Engineers Comments Regarding Surface Water Drainage

Application Reference:	BR/41/26/PL	Reviewer Reference:	ADC/KW/PC
Planning Officer:	Amber Willard	Date of Review:	29/04/2026
Site Name:	Belmont Lodge, Belmont Street, PO21 1LE		
Application Description:	Retention of a single storey office building.		
Assessment Number:	2 of 2

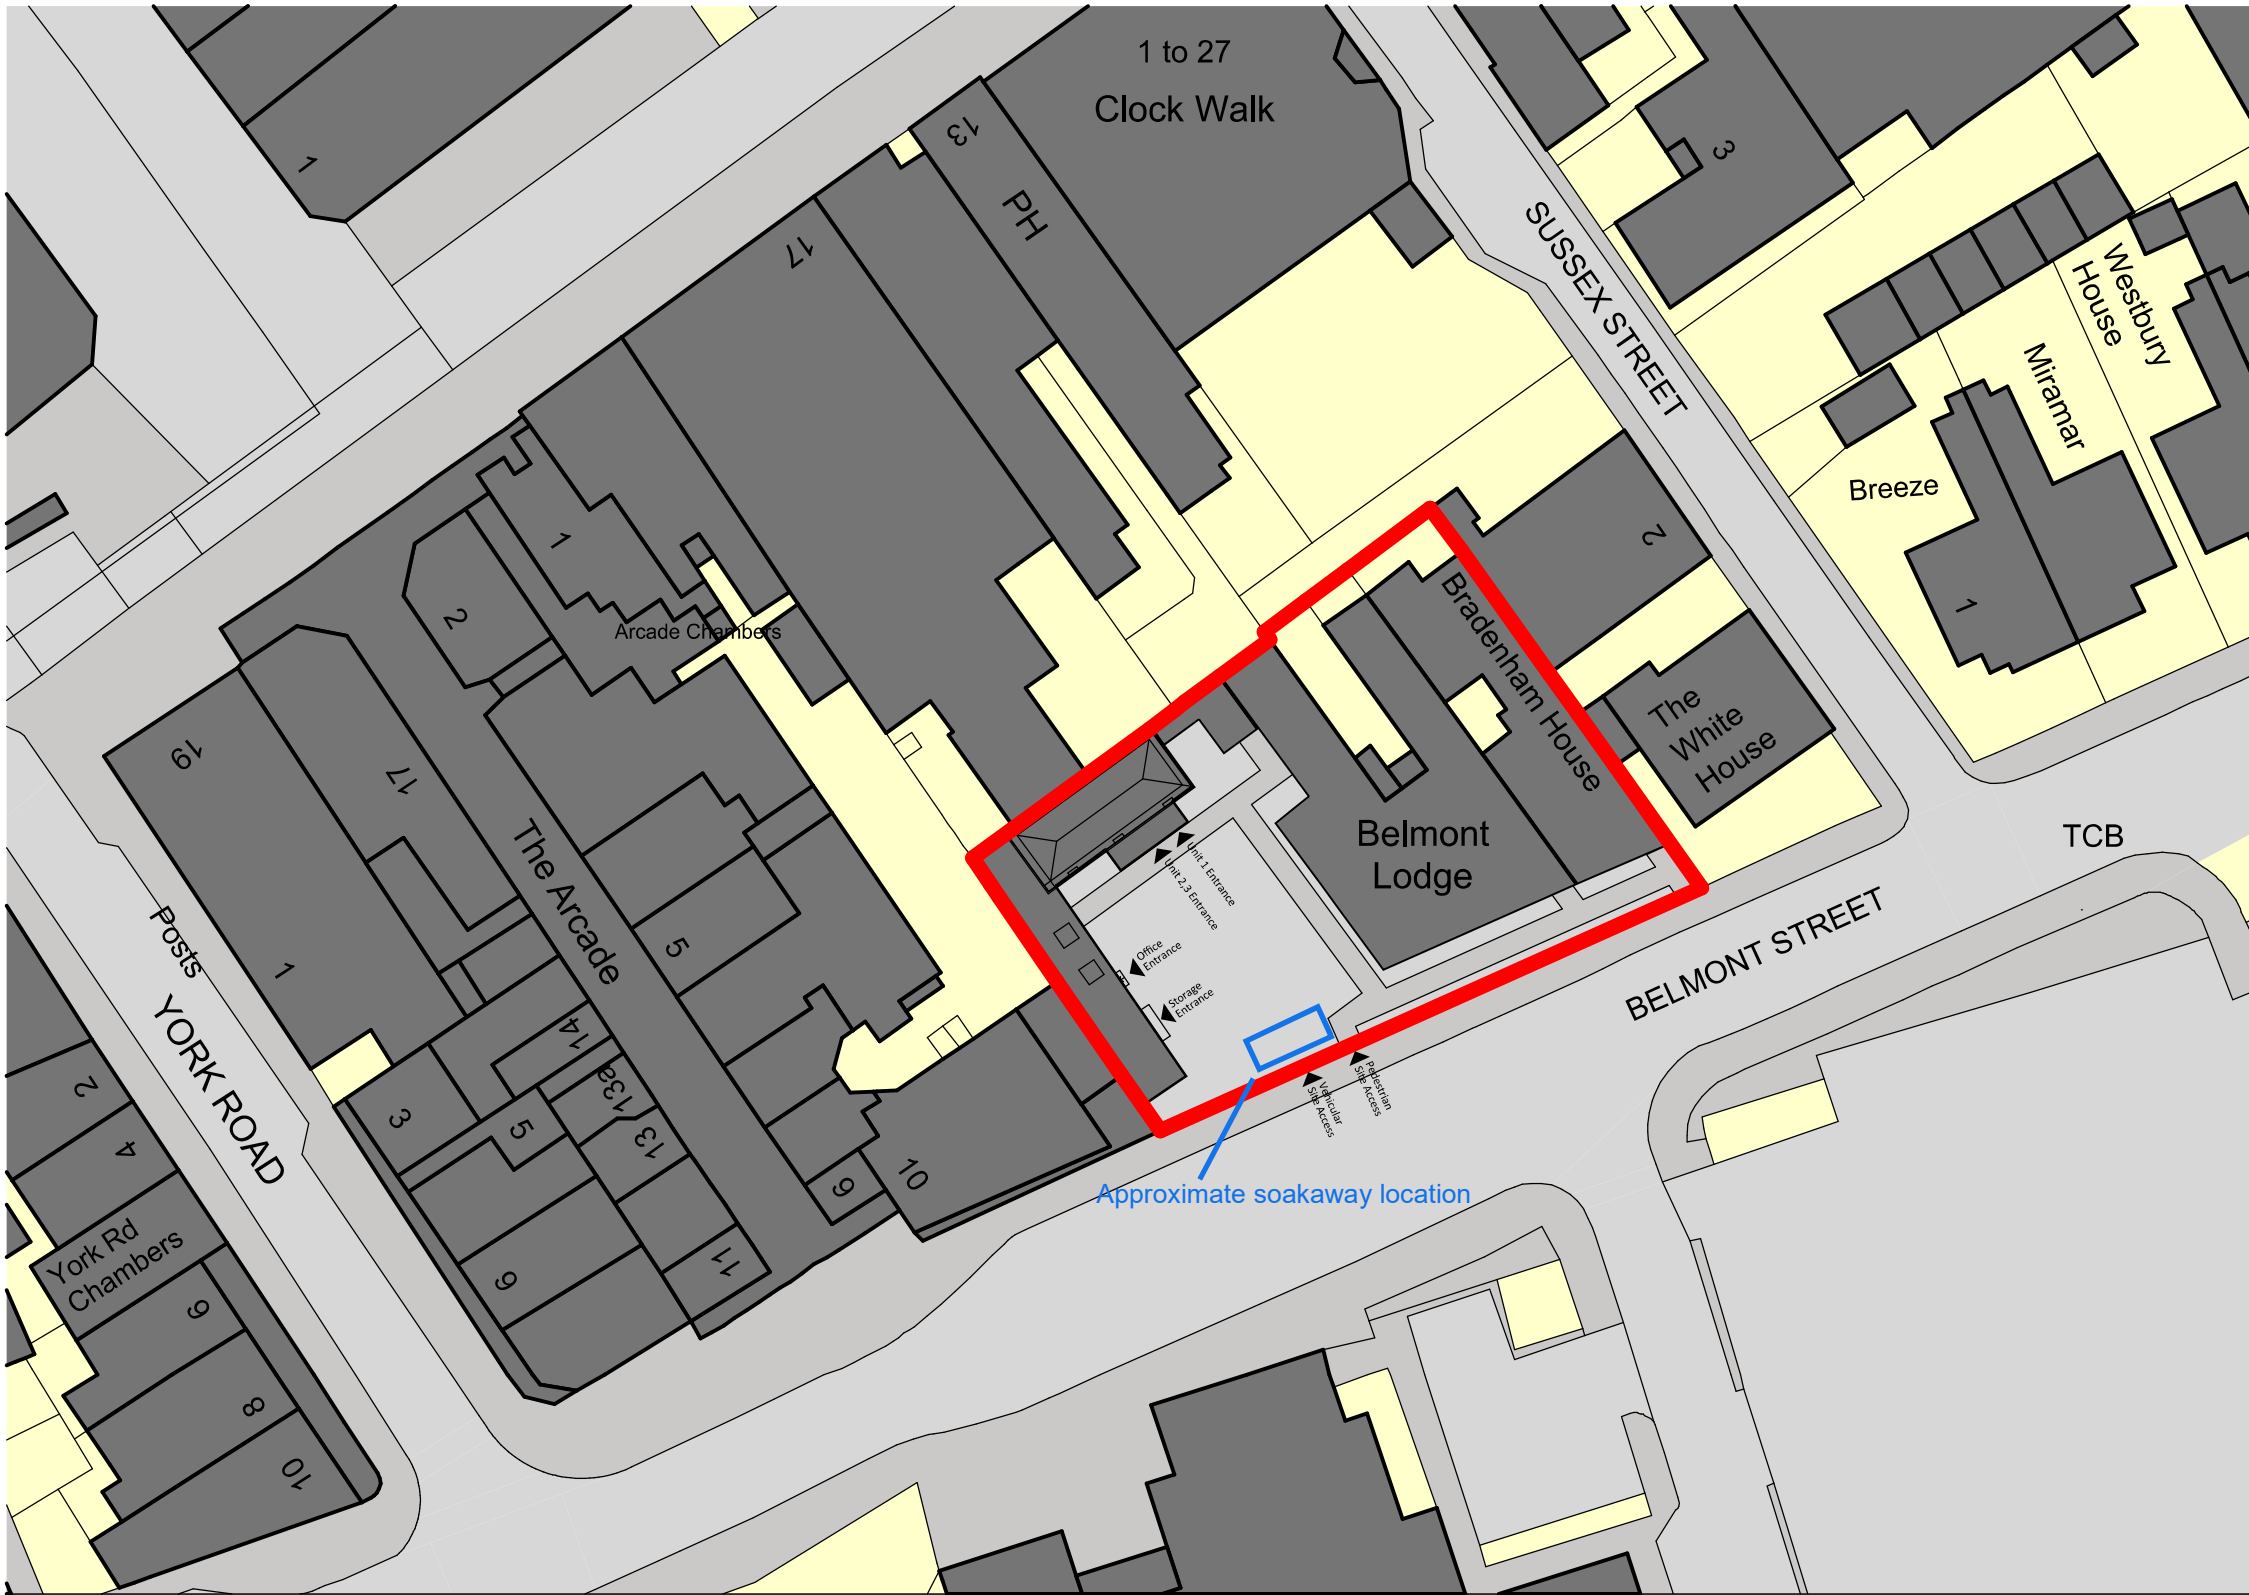
0.1. Details have now been submitted explaining that the carpark is afforded a soakaway in an approximately location of the vehicular access into site.

1.1. It is proposed to discharge surface water falling on the roof of the office building to an existing soakaway found on site, located under the carpark. Water collected in the soakaway is then infiltrated into the ground. While infiltration is the highest priority discharge location (except for water re-use) and accords with Standard 1 of the NSfS, insufficient information has been provided to ensure the existing system is appropriate for its intended use. As insufficient evidence has been

submitted to demonstrate how the applicant intends to drain surface water, we are unable to assess whether the proposed development would increase flood risk. It is the responsibility of the applicant or their drainage designer to provide this evidence. For this reason, **we object** to the proposal, as the submission of such evidence may affect the scale and layout of the development.

- 1.2. Evidence of ground conditions along with evidence of the existing drainage system will be required. Without understanding ground conditions or the capacity or contribution areas of the existing system, it is not possible to ensure that flood risk is not being increased.

- 1.4 A public surface water sewer and combined sewer can be found in the highway to the front of site. No information regarding this option has been submitted. If infiltration is not viable, the applicant would need to investigate the possibility of connecting surface water to the sewer at the front of the site including undertaking a hydraulic capacity check. The applicant would also need to demonstrate that a gravity connection is achievable. No information regarding this option has been submitted.

3.2. Notably, the approximate location of the existing soakaway lies within the future flood risk area (defended). SuDS should not be sited in areas of flooding as during a flood event this could result in the loss of either floodwater or surface water SuDS storage. This would mean that the features could be inundated by floodwater prior to runoff entering them, or vice versa, thereby rendering them ineffective. One exception to this rule is if the risk of flooding is isolated to tidal sources only. Product 4 data from the Environment Agency should be requested by the applicant to identify the source of flood risk involved on site.
